TALASAEA
CONSULTANTS, INC.

TAL-1129B

REFERENCE: **Hou Critical Areas Determination**
FILE NOS.: CAO17-010 and SEP19-003, Ecology SEPA #201900882
SUBJECT: Response to City of Mercer Island Comment Letter

**CRITICAL AREAS MITIGATION PLAN
 PROPOSED SITE PLAN, IMPACTS & MITIGATION PLAN
 HOU PROPERTY
 MERCER ISLAND, WA**

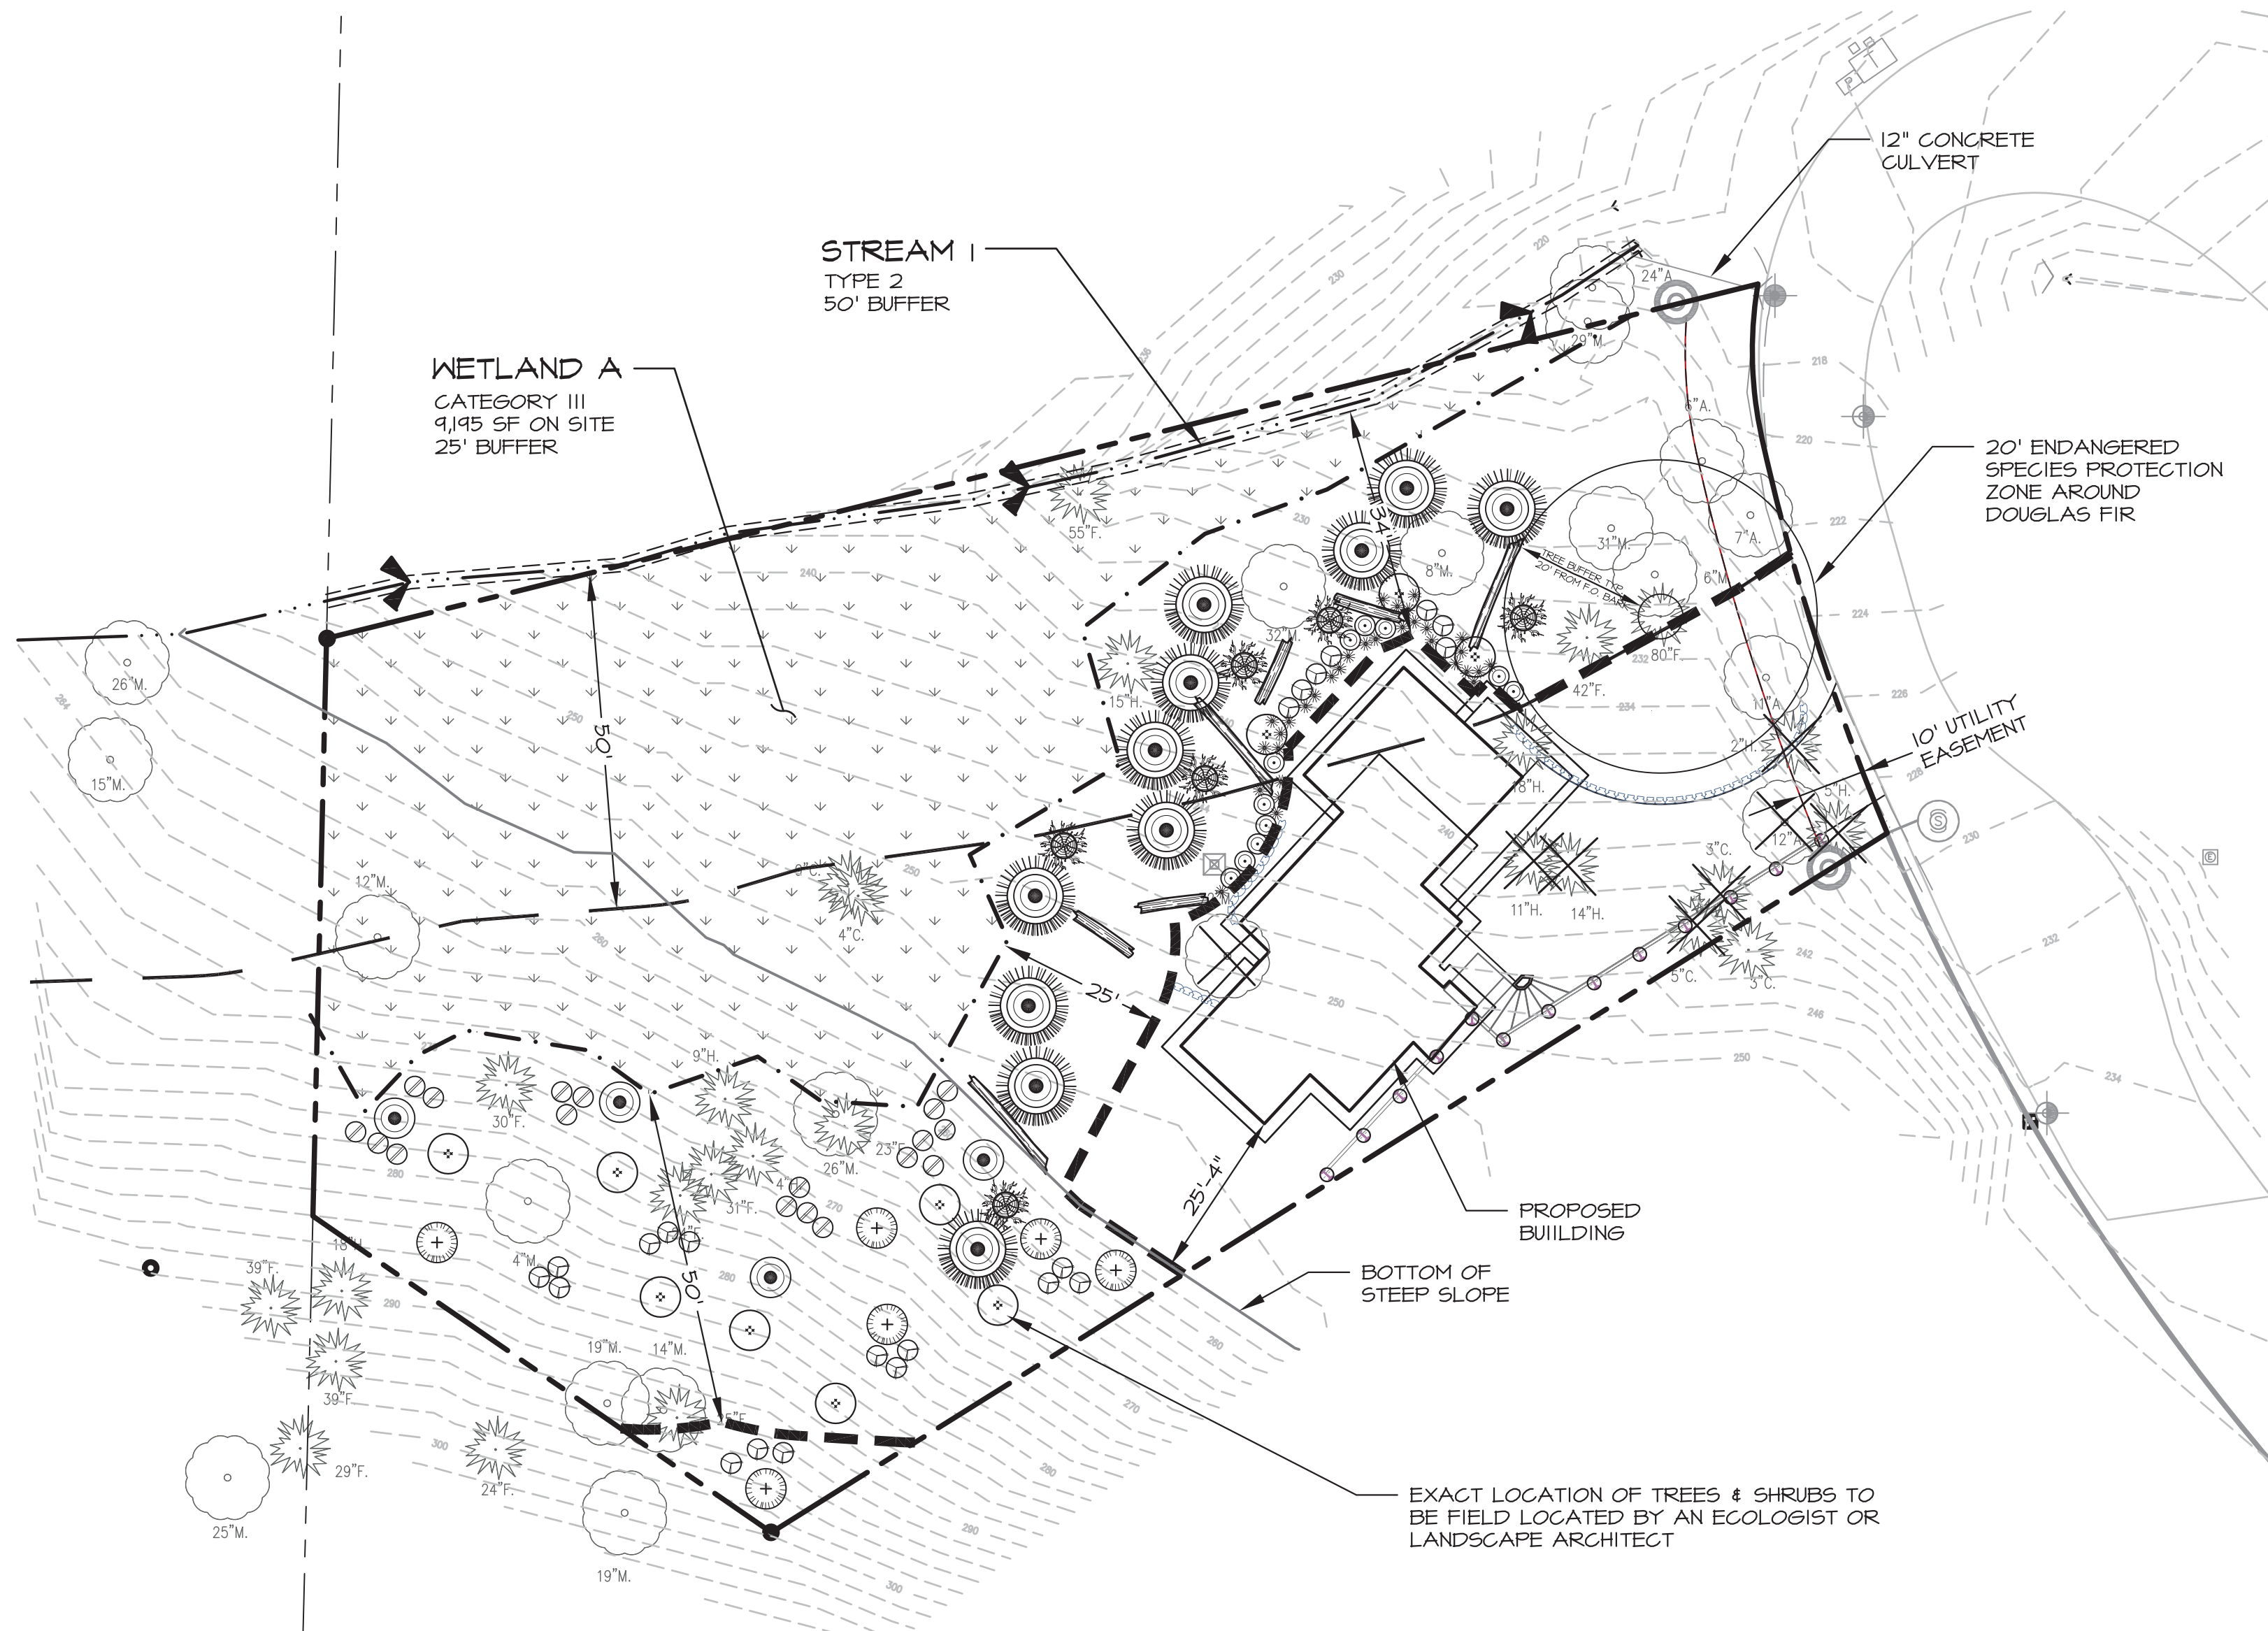
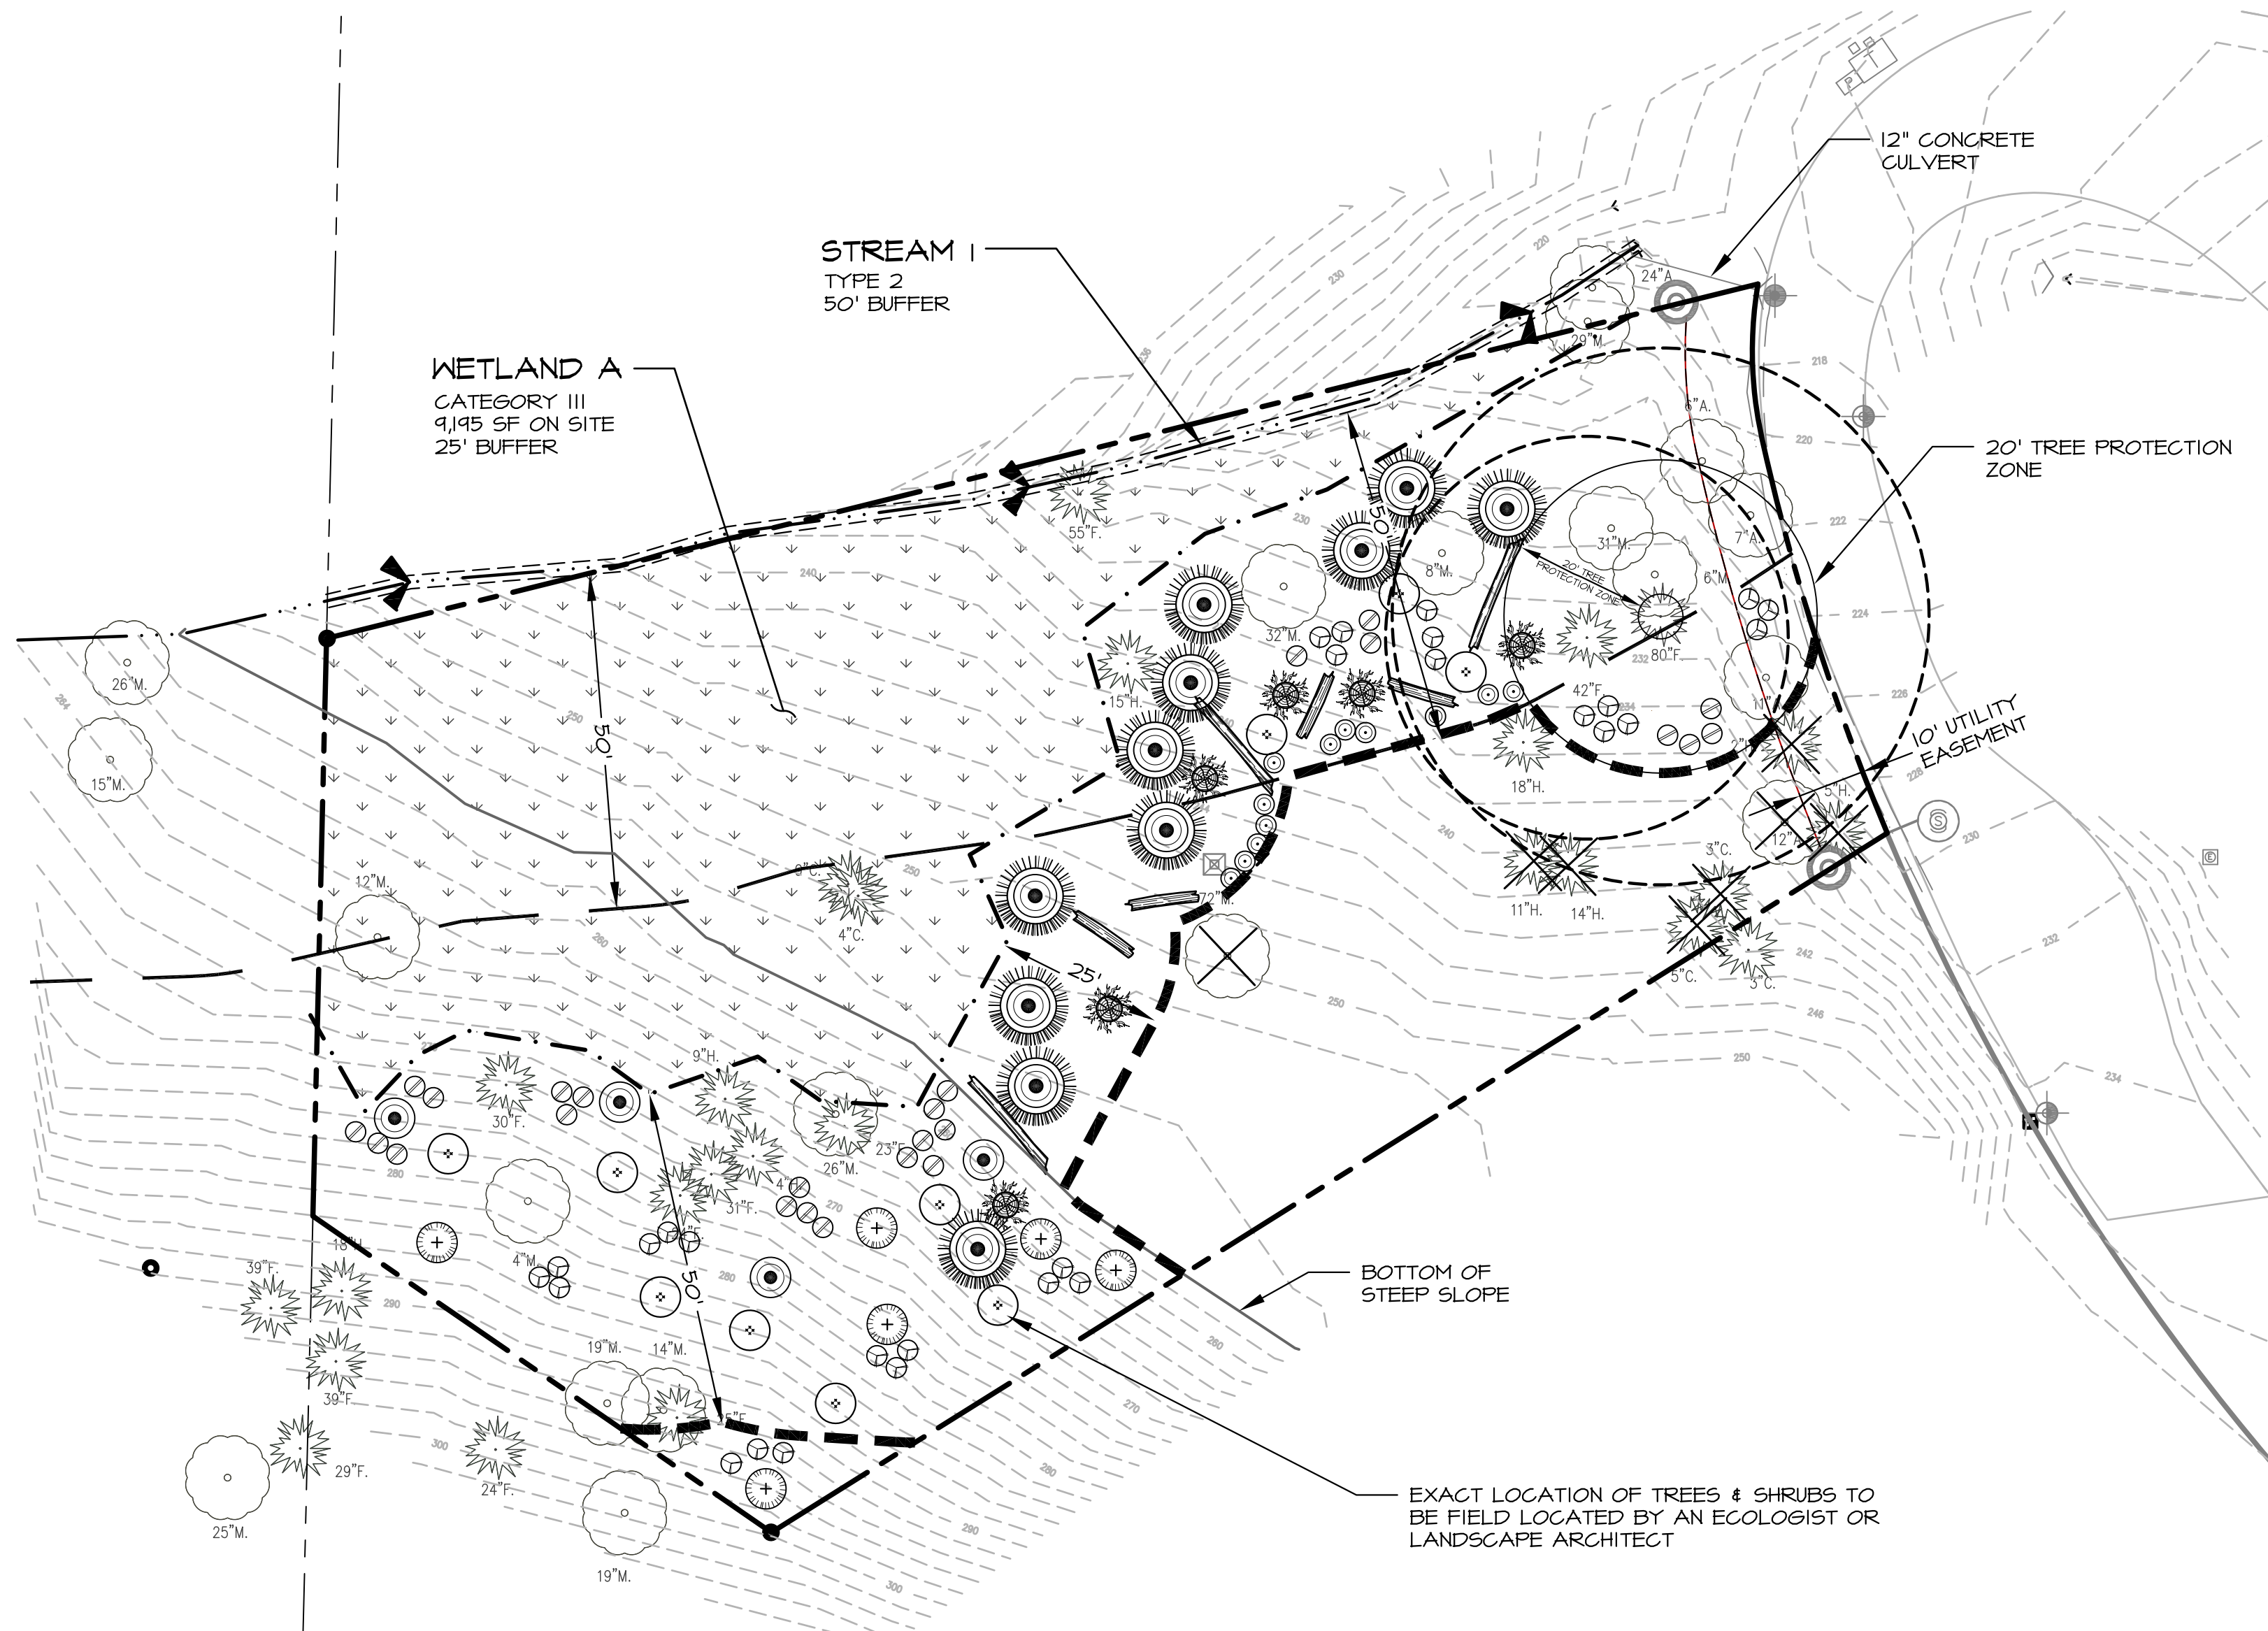
Ecology would regulate the wetland as a water of the state subject to the applicable requirements of state law (see RCW 90.48 and WAC 173.201A) and Section 401 of the Clean Water Act (33 USC §1341) and 40 CFR Section 121.2. We are concerned about the buffer encroachment and do not support building the house so close to the wetland. This is not consistent with Ecology guidance on buffer widths in Wetland Mitigation in Washington State – Part 1: Agency Policies and Guidance (Publication #06-06-011a).

That said, the wetland buffer is being reduced to 25 feet for a short segment, with some buffer give-back provided in conjunction with vegetative enhancement of the remaining buffers to compensate for the reduced buffers. This is necessary to provide a buildable area on this lot that would otherwise be undevelopable. This parcel and associated critical areas are located within the boundaries of the City of Mercer Island, a relatively densely developed jurisdiction considering it is mostly single-family residences. The presence of critical areas cannot preclude development on this lot as it is zoned for residential use and is surrounded by single-family residences. Every step has been taken to avoid direct impacts to the wetland, to minimize indirect impacts to the wetland as much as possible given the development constraints on this Site, and to mitigate for the anticipated indirect impacts from the reduced buffer. No further modifications to this wetland buffer are anticipated, nor are any changes proposed as a response to this question.
